Subject: objecting to planning application 2023/93544

Drawing Number
0022-100-RG

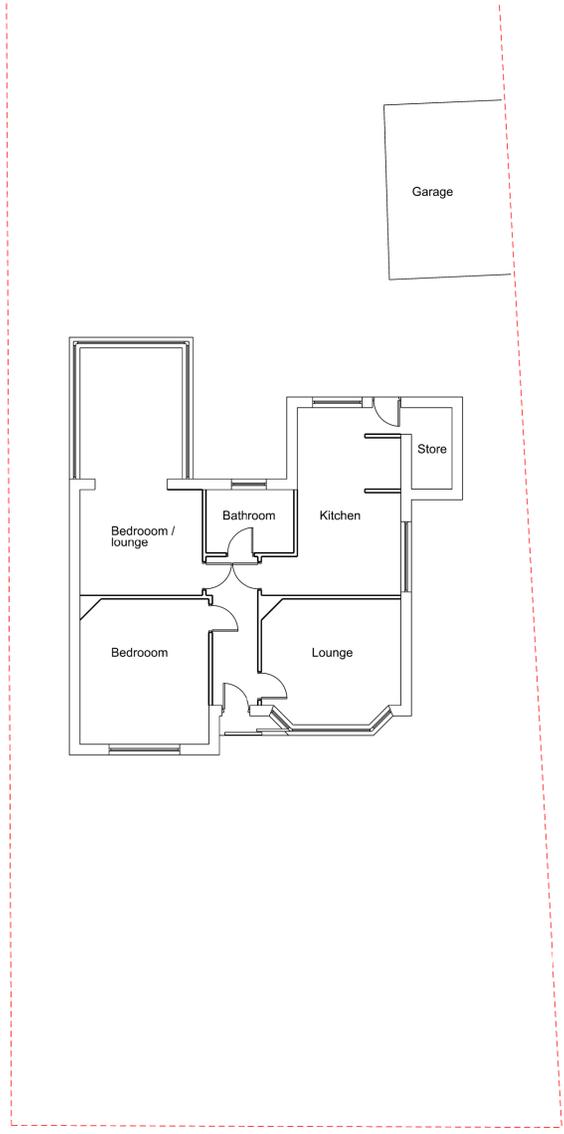
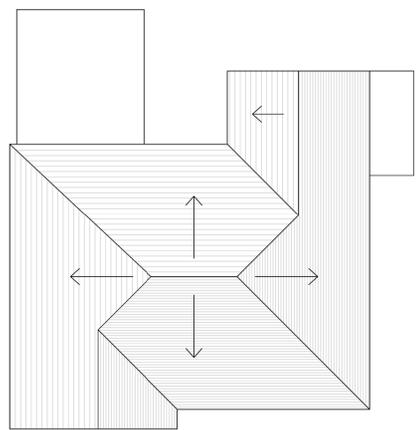
I have no objection to an increased footprint from the current building, I do however have concerns with the architects' drawings and how accurate the measurements are, in relation to gaps between the houses, height, length, driveway etc. "Design and Access Statement" document, look at the 1246 measurement to the existing garage.... From this measurement a car would not pass and from the photo included one definitely does.

The planned drawing shows almost 2/3 of the garage is currently blocked by the current / existing building. The photo shows this not to be the case. Looks like an extra couple of meters would be used for the house.
